Lower Thames Crossing

5.4.1.6 Final Agreed Statement of Common Ground between (1) National Highways and (2) Natural England (Clean version)

DATE: December 2023
DEADLINE: 9A

Planning Inspectorate Scheme Ref: TR010032
Application Document Ref: TR010032/APP/5.4.1.6

*Local Landscape Character Area boundaries of the Kent Downs AONB LCA, West Kent Downs, Sub-areas Cobham and Shorne*

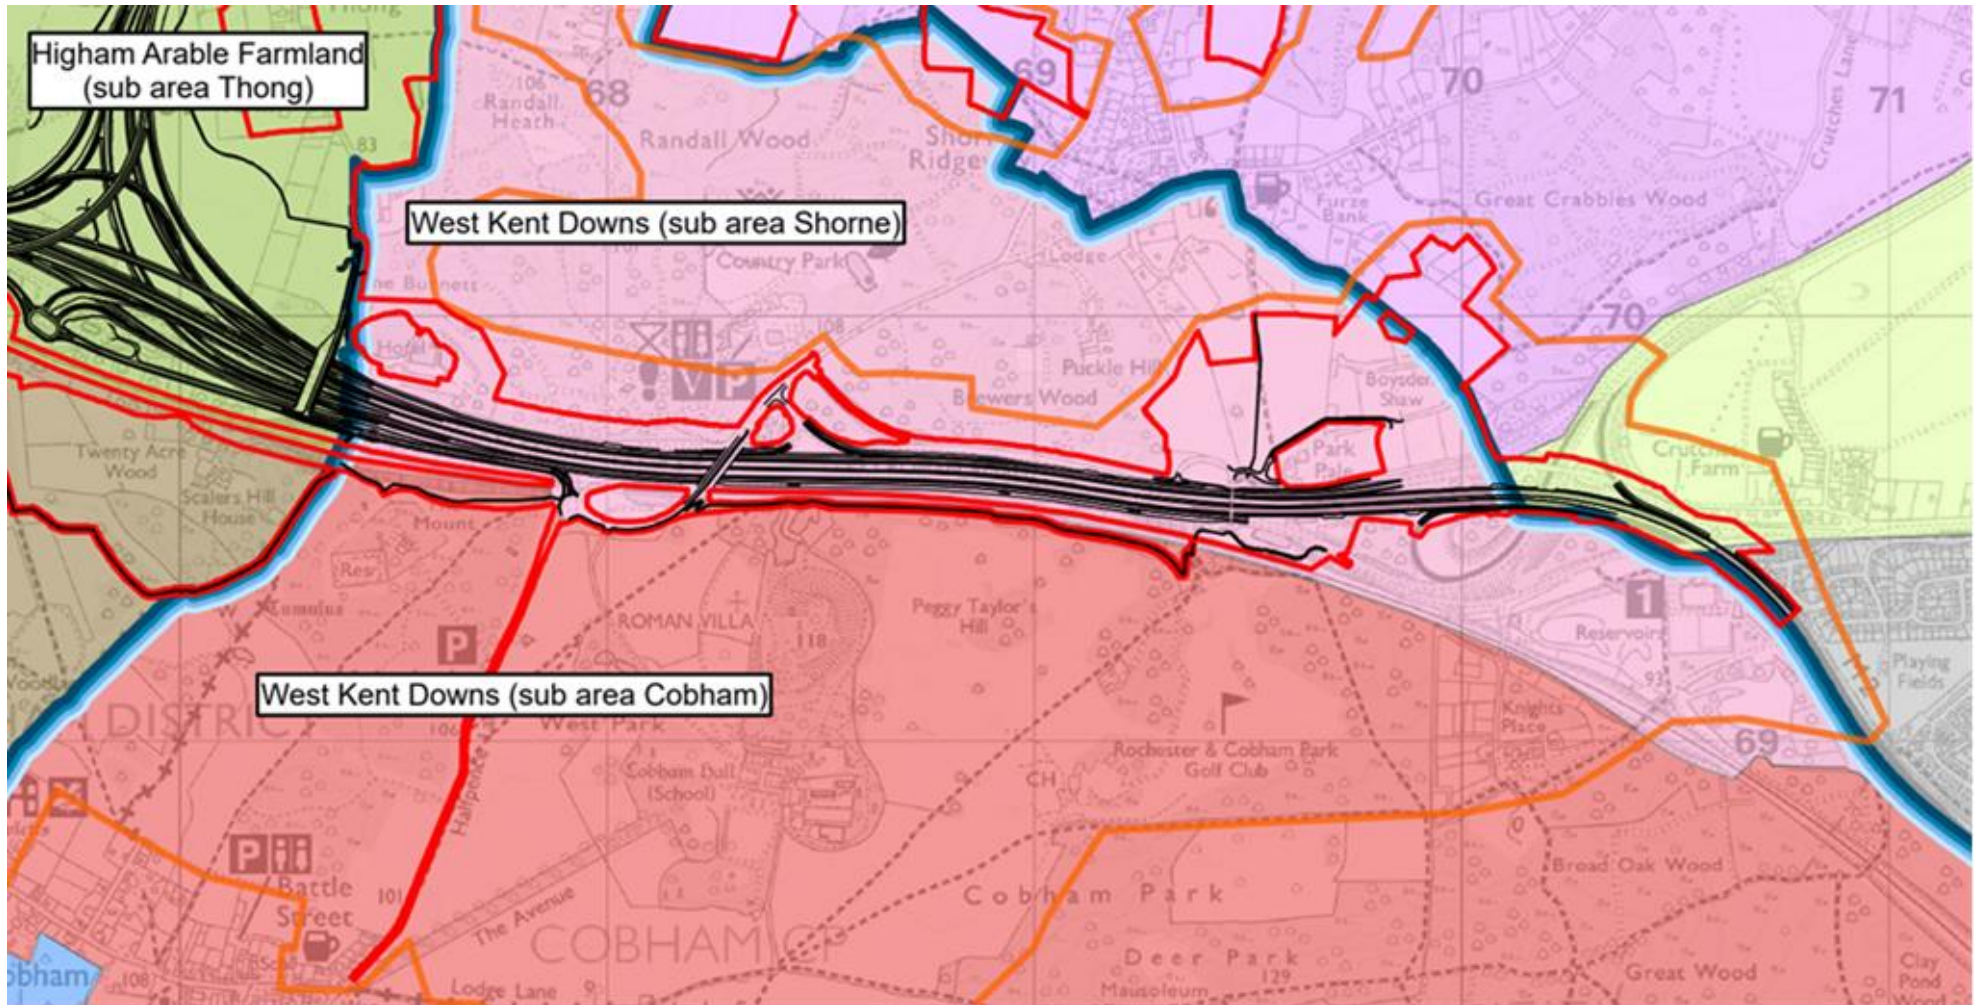
Topic	Item No.	Natural England Comment	The Applicant's Response	Application Document Reference	Status
				10.1.1 – 10.1.4 [REP1-262]	
Landscape and visual					
Visual					
Baseline	2.1.105 WR (DL5)	<p>The Environmental Statement appears to show incorrect boundaries for the contiguous West Kent Downs (sub area Cobham) and West Kent Downs (sub area Shorne) Local Landscape Character Areas (LLCA). The Cobham sub area boundary largely follows the northern boundary of the existing A2/High Speed 1 Rail Line alignment whereas the Environmental Statement shows the same Character Area boundary running to the south of the A2/High Speed 1 Rail Line. The incorrect transposition of the boundaries for these two sub-Character Areas is likely to mean that the assessment of landscape and visual effects within the Environmental Statement are incorrect.</p> <p>Natural England has reviewed the Applicant's without prejudice assessment using the published LLCA boundaries [REP8-110] and our advice remains that the Environmental Statement should have</p>	<p>The boundaries of the LLCAs within the Kent Downs AONB have not been incorrectly transposed. As detailed in Appendix A of Comments on Written Representations, the boundaries of character areas identified in the studies have been used to inform the definition of the LLCAs, which have been used as a basis for the assessment of effects on the landscape at the local level. In a limited number of locations, the boundaries of the published character areas have been slightly adjusted through detailed study and analysis undertaken for the LVIA.</p> <p>Notwithstanding this slight difference in the West Kent Downs (sub area Cobham) LLCA boundary, the effects of the Project are fully assessed either as direct or indirect effects within the West Kent Downs (sub area Cobham) LLCA and/or the neighbouring West Kent Downs (sub area Shorne) LLCA. The findings of these two assessments are then brought together into a combined assessment for the overarching West Kent Downs</p>	<p>ES Chapter 7: Landscape and Visual [Document Reference 6.1 ES Chapter 7 (2)] Comments on Written Representations Appendix A- Statutory Environmental Bodies [REP2-046] Natural England's Written Representation paragraphs 6.1.3, 6.1.4 and 6.1.7 [REP1-262] Post-event submissions, including</p>	Matter Not Agreed
